CITY OF ALBUQUERQUE

Re: Peak Motion, 7424 Holly Ave NE,
Request for Permanent C.O. –Not Accepted
Engineer's Stamp dated: 12-12-12, (C19/D057)
Certification dated: 5-6-13

C101

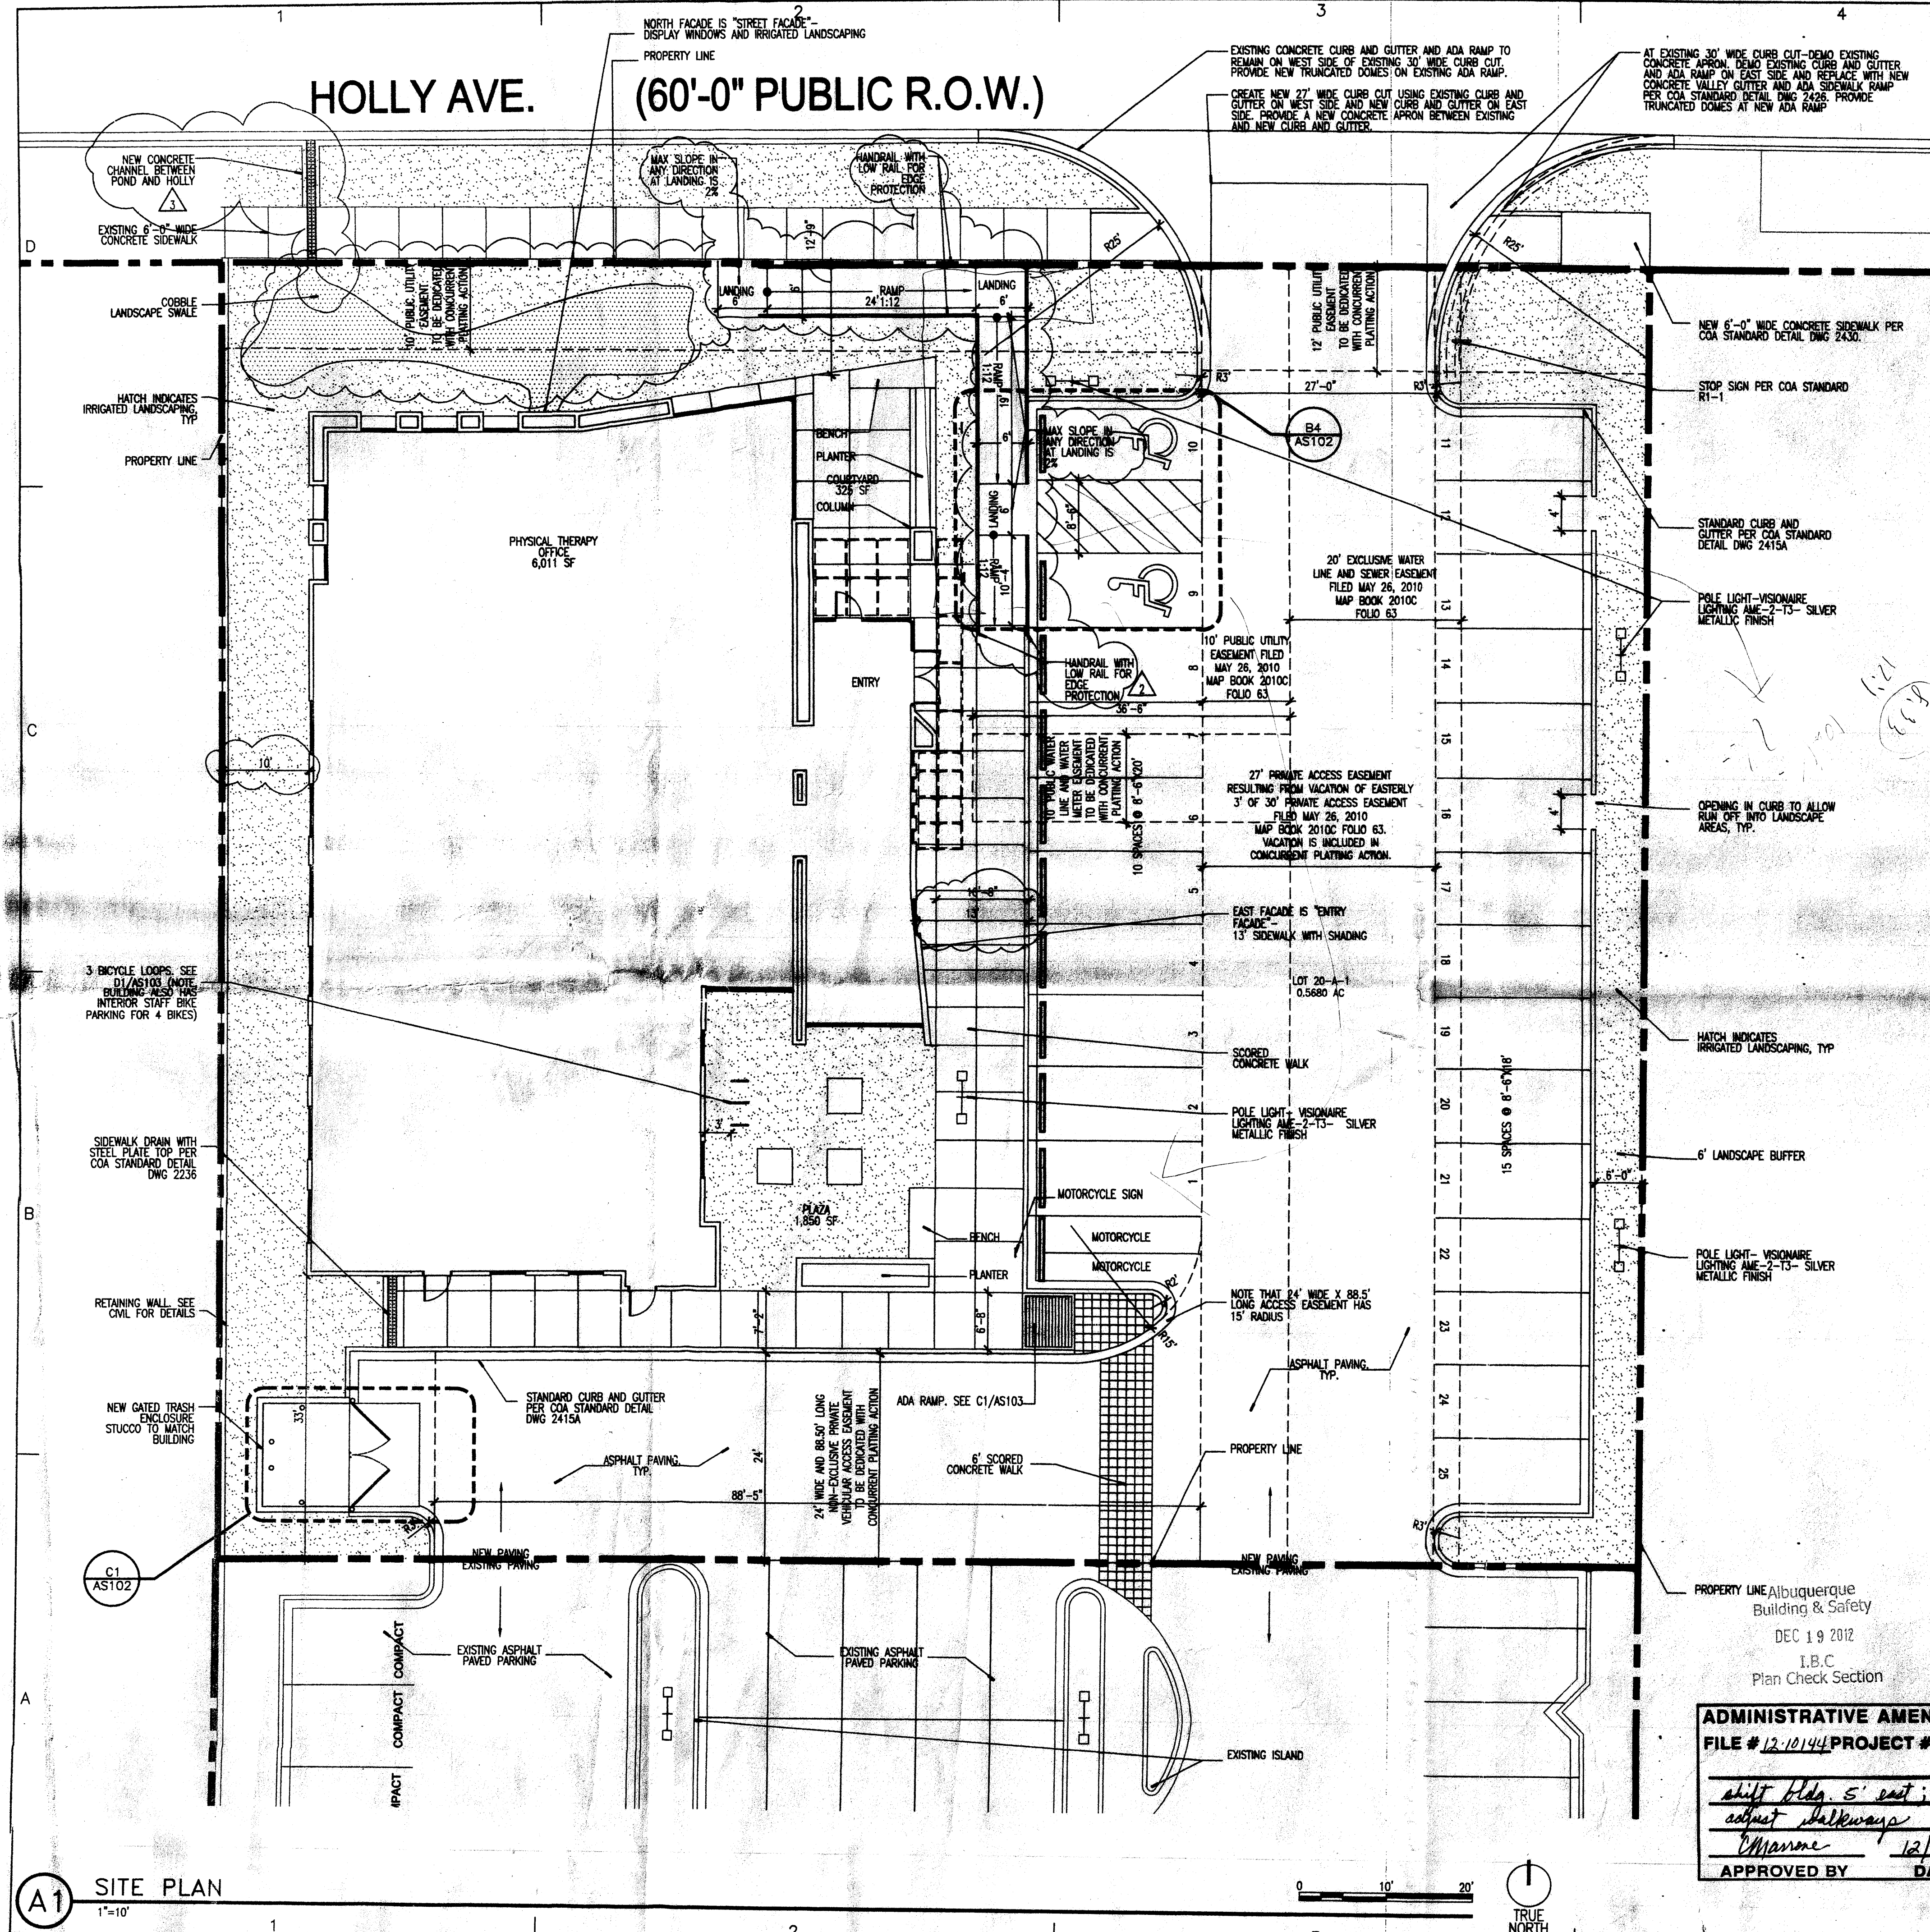
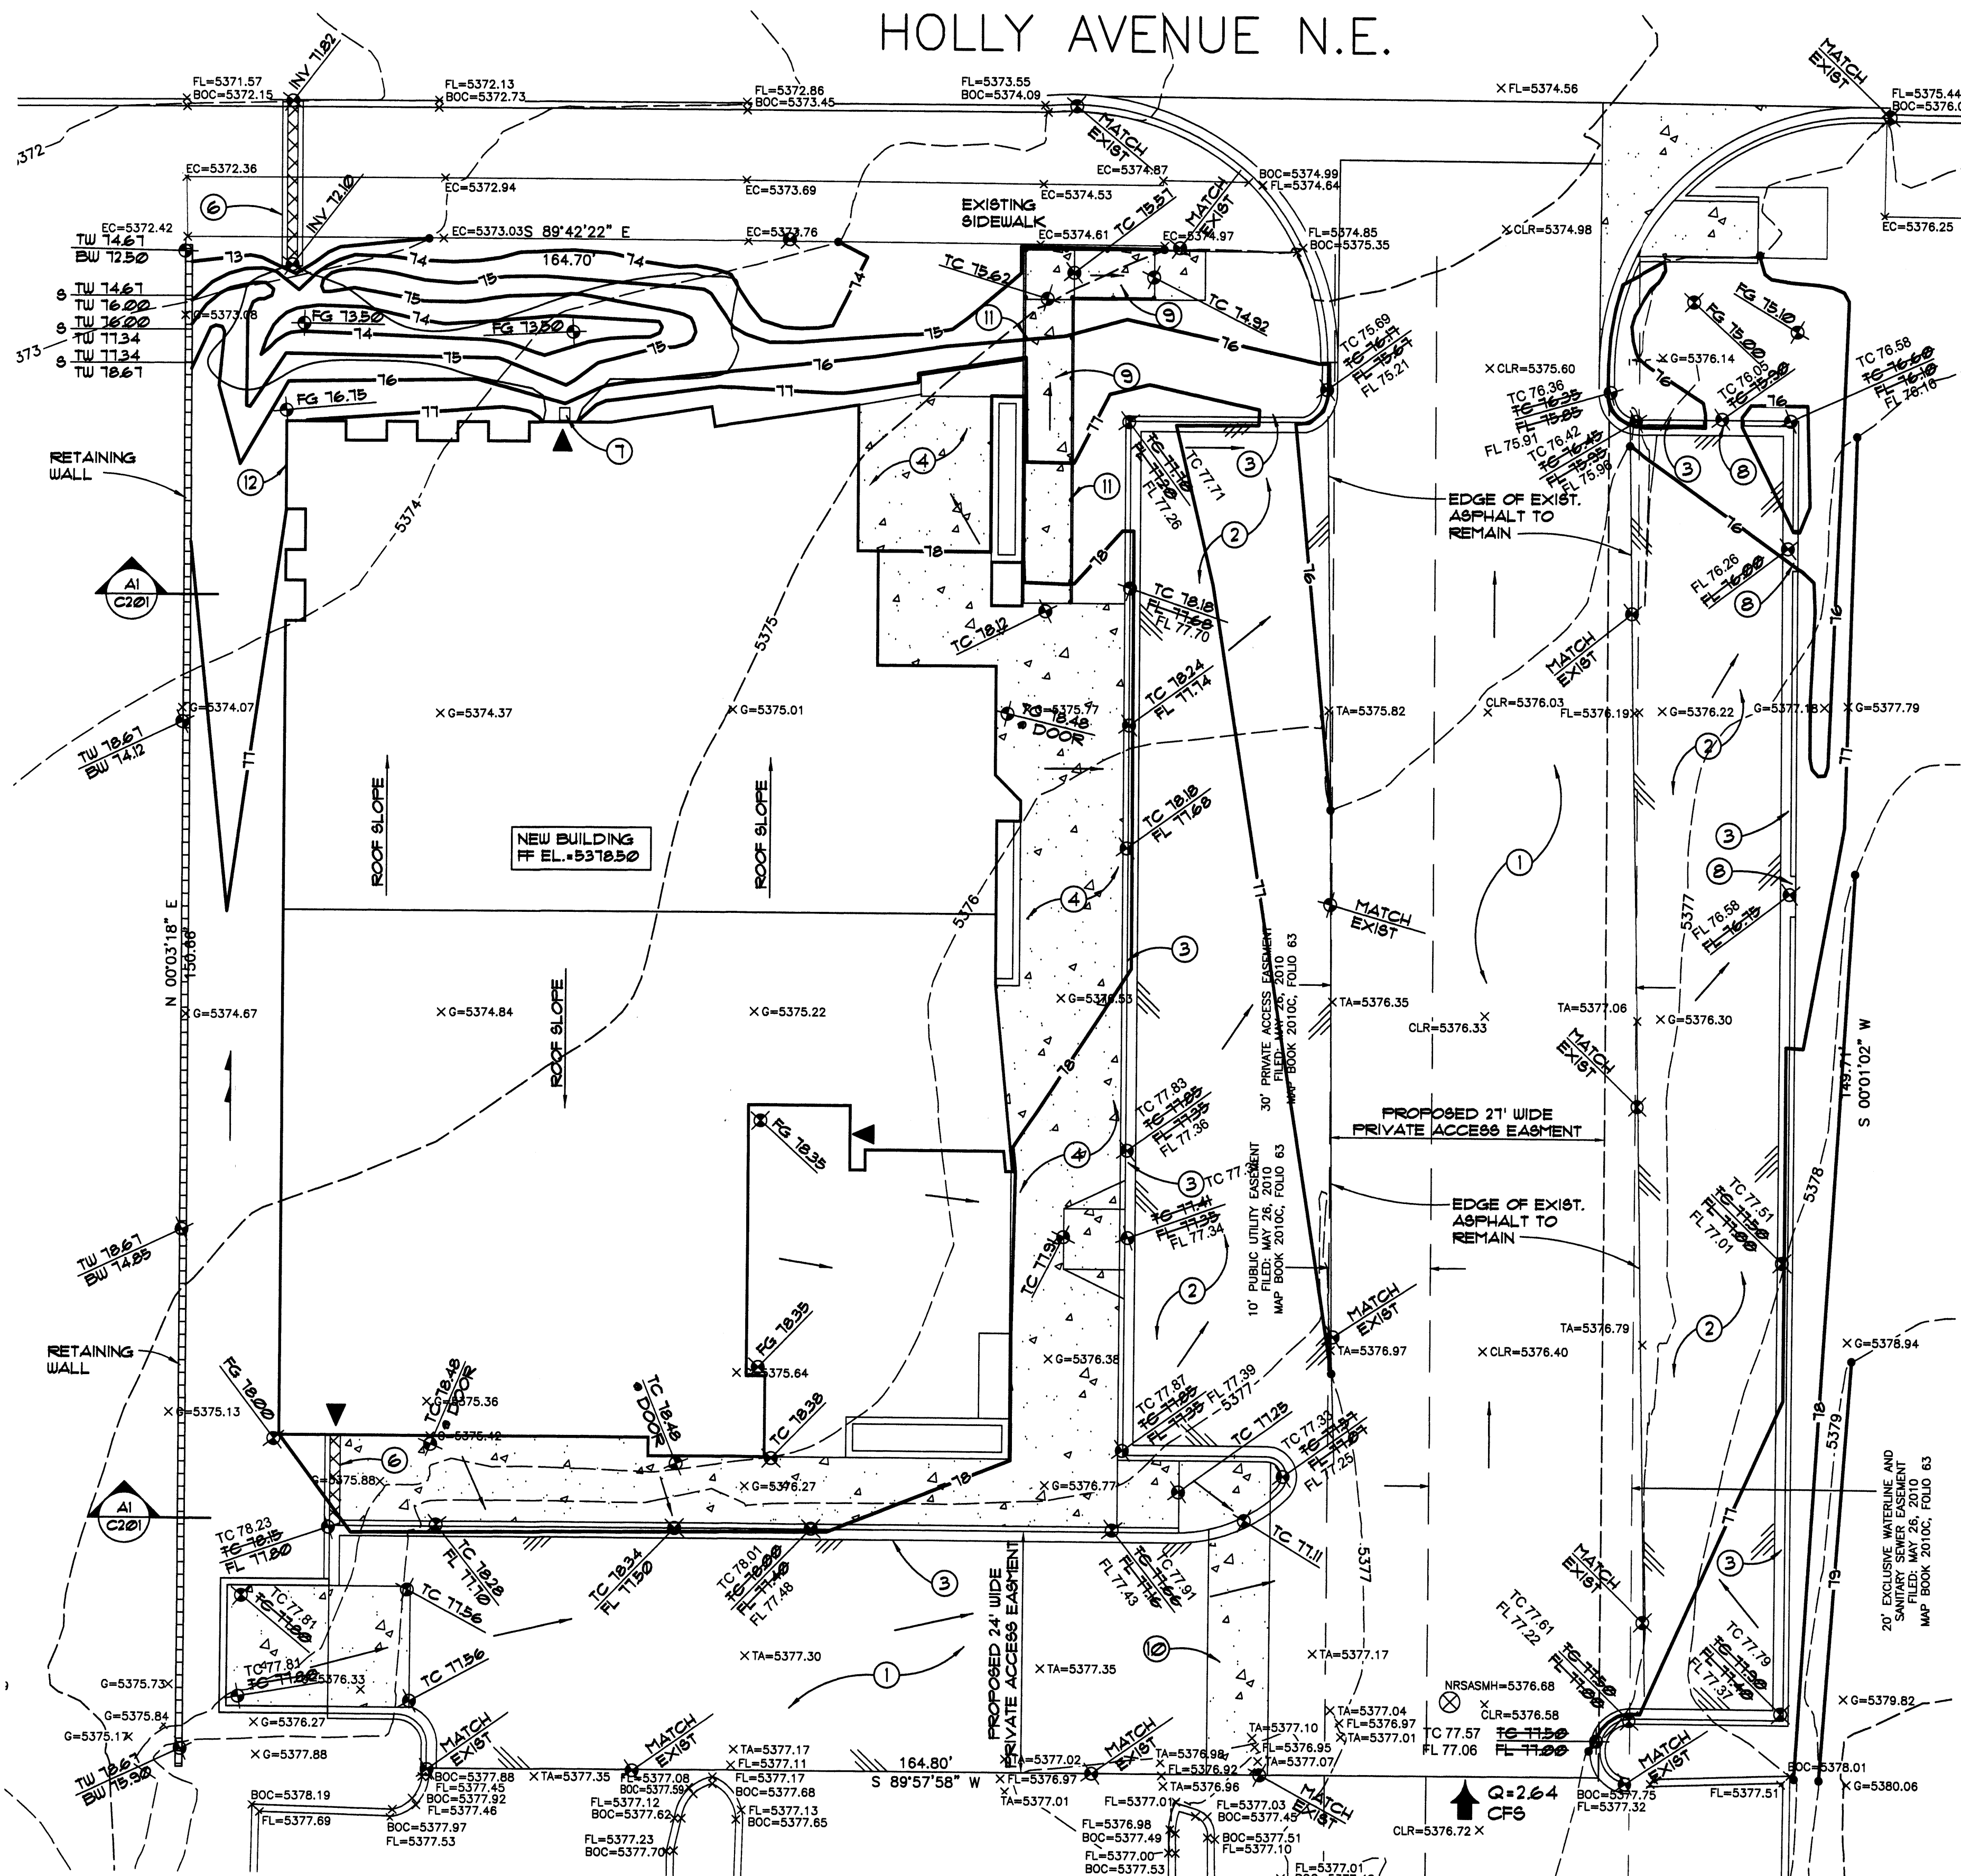
- Under the Engineer Certification the width of the sidewalk culvert must be included in the exceptions section along with the length of the plate passed the property line toward the building. Also, verify the capacity of the sidewalk culvert.
